To: Anita Gardner [REDACTED]
Subject: FW: 23314 Wicks Farm Glasshouse and Reservoir F/30/18/PL

All of the attached relate to Drainage Conditions at Wicks Farm – Glasshouse & Reservoir – F/30/18/PL. As Paul Cann is now satisfied with the improvements; please could you Discharge Conditions 4, 5 & 8.

From: Stuart Magowan [REDACTED]
Sent: 29 June 2021 13:11
To: Paul Cann [REDACTED]
Cc: CEP | Reception [REDACTED] John Hall [REDACTED]
Subject: 23314 Wicks Farm Glasshouse and Reservoir

TITLE
Proposed Levels and Drainage
Sheet 1 of 6

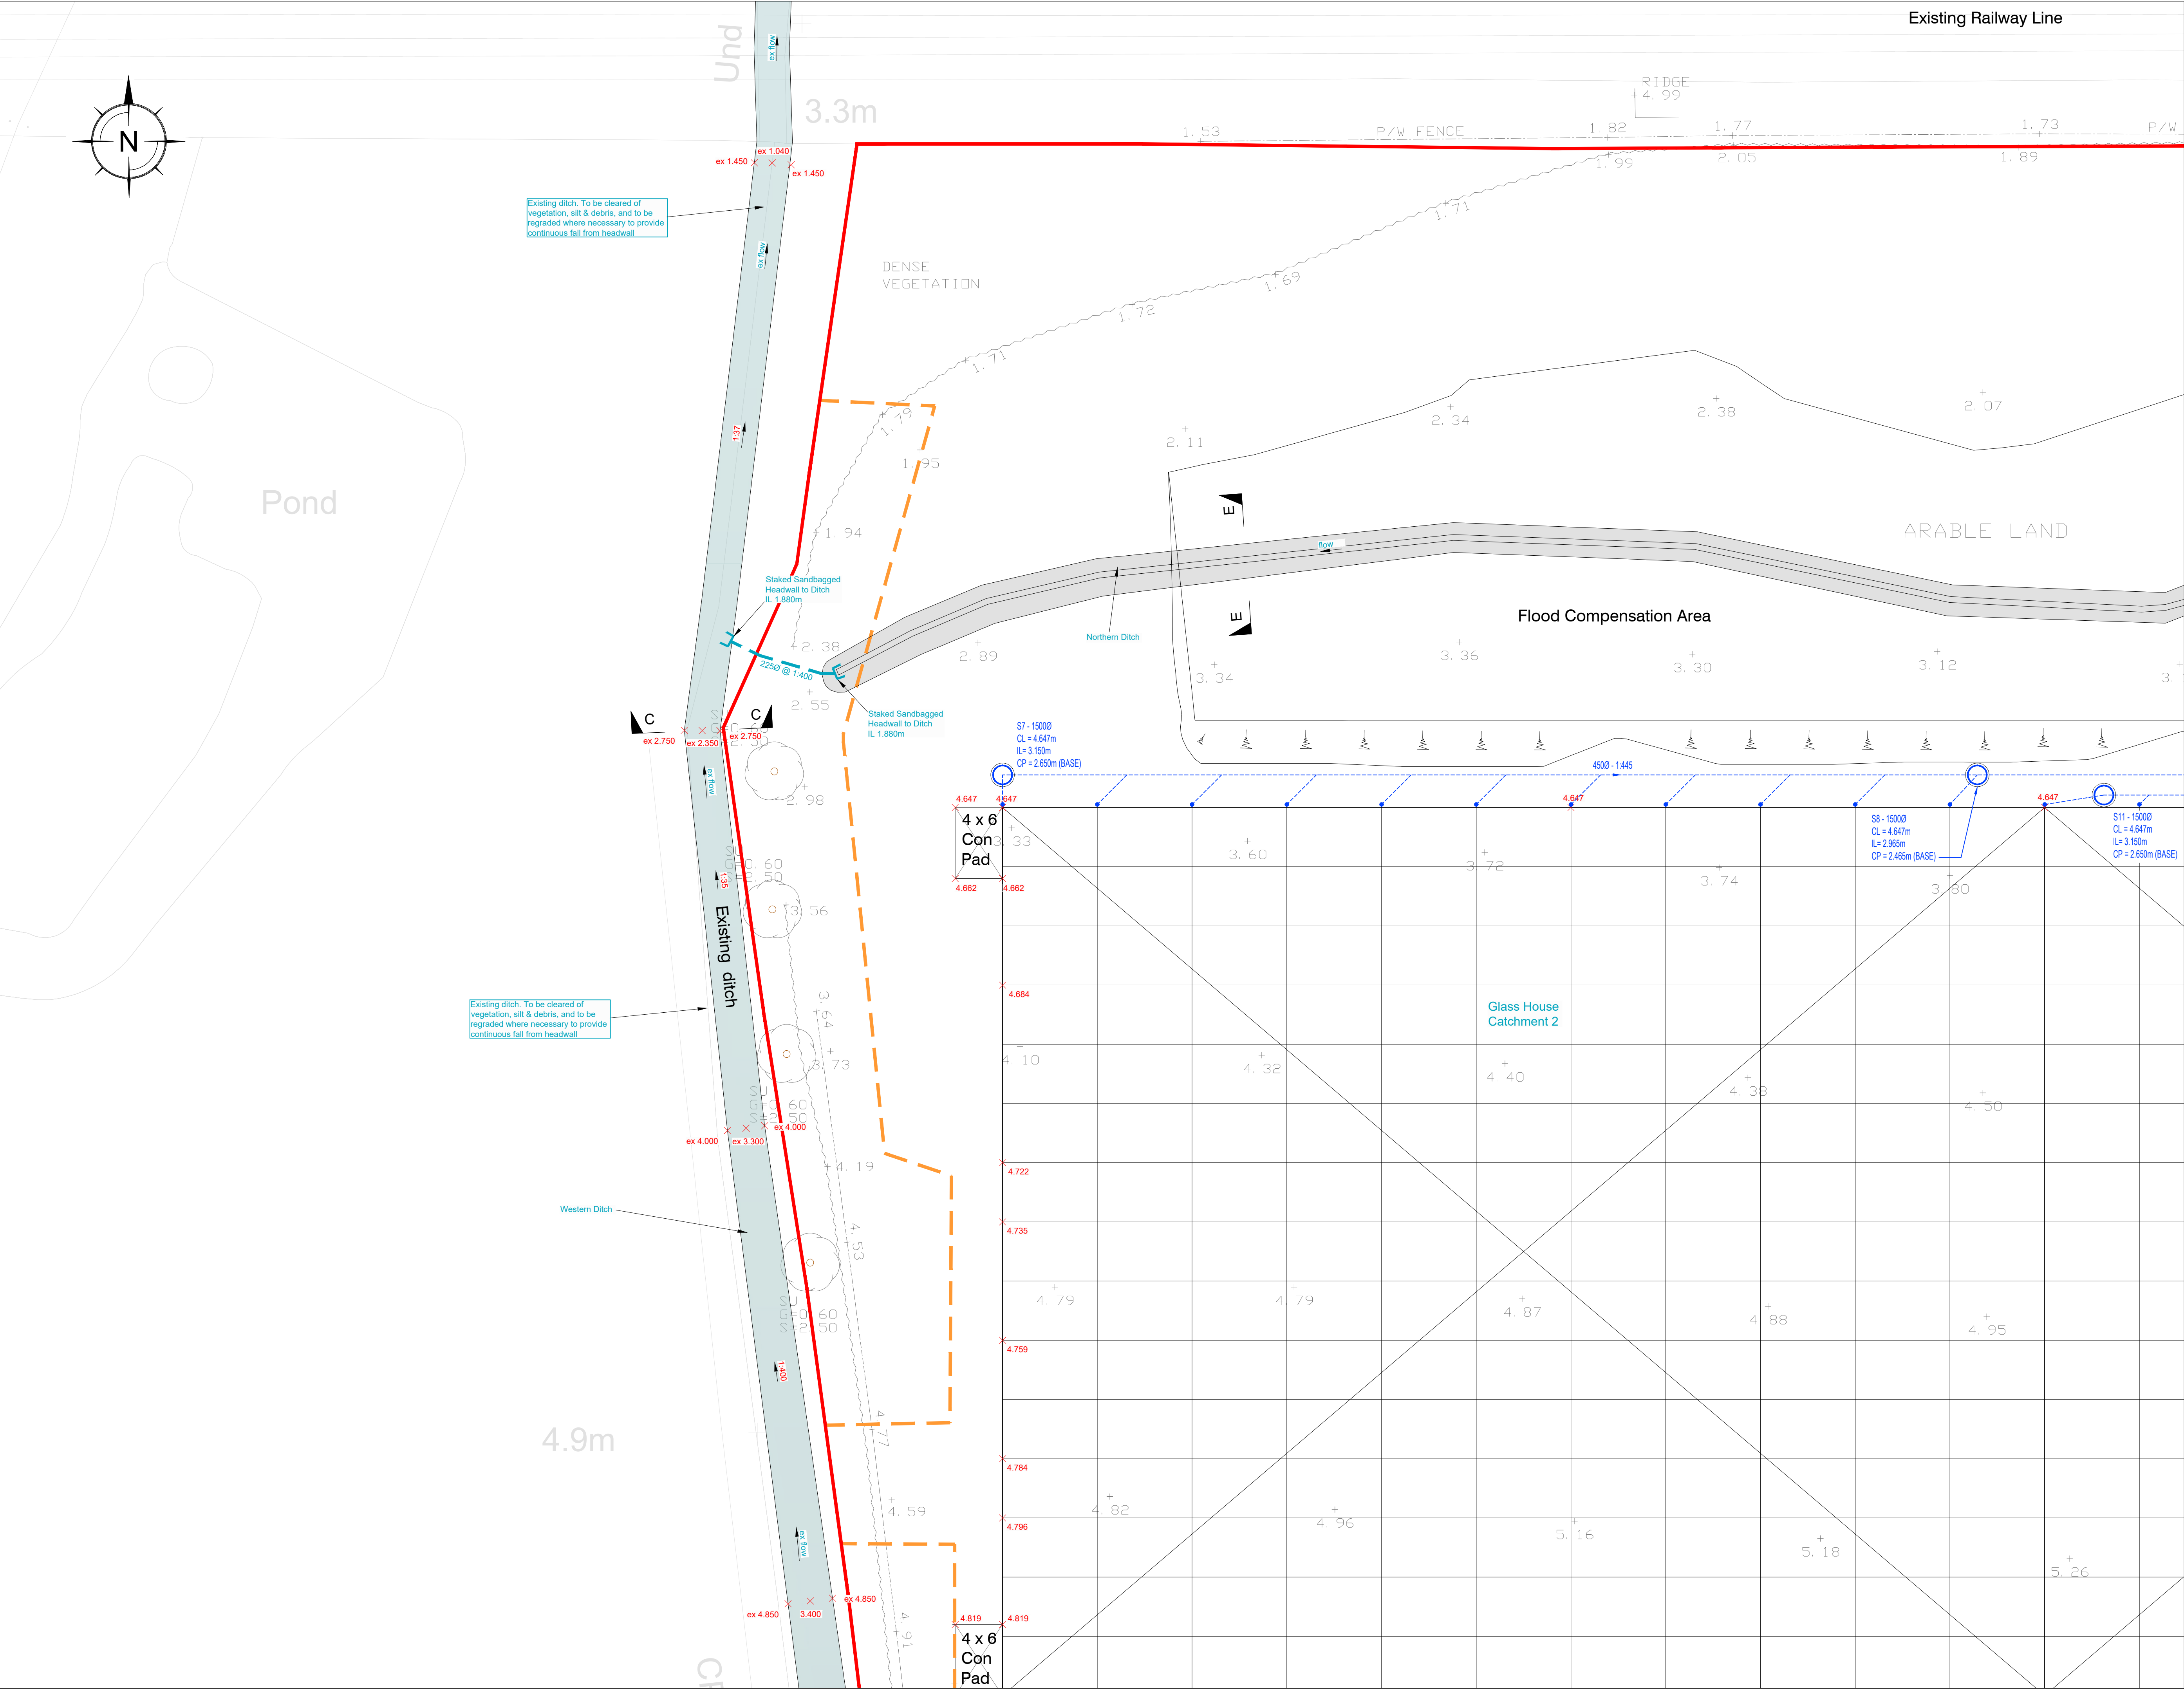
1. Agree
2. Agree
3. Agree - I assume the 'as constructed' invert of the hydrobrake chamber does not affect this proposal.
4. Agree
5. Swale Inter connections - Agree. 2 x 600mm pipes is the preference. NB. Cranked grilles to be fitted as per the original approval.

6. Main swale - agree
7. Outlet from main swale – should pipe invert level be 3.800? No objection to the 150mm pipe but the cranked grille will need adjusting to suit the revised diameter.

8. Western ditch culverted – removal of pipe noted. Hopefully ditch has been reinstated to a good order.
9. Filter drainage outlet - agree
10. Glasshouse roof drainage - agree

11. Northern ditch/swale – agree. At the upstream end of the swale there is a 225mm pipe bypassing the main reservoir hydrobrake. What is this draining? I note some form of secondary control chamber – please provide further details. Upstream of this secondary control there is a chamber (IL 3.62) with an acute angle pipe arrangement which is not desirable – please advise.
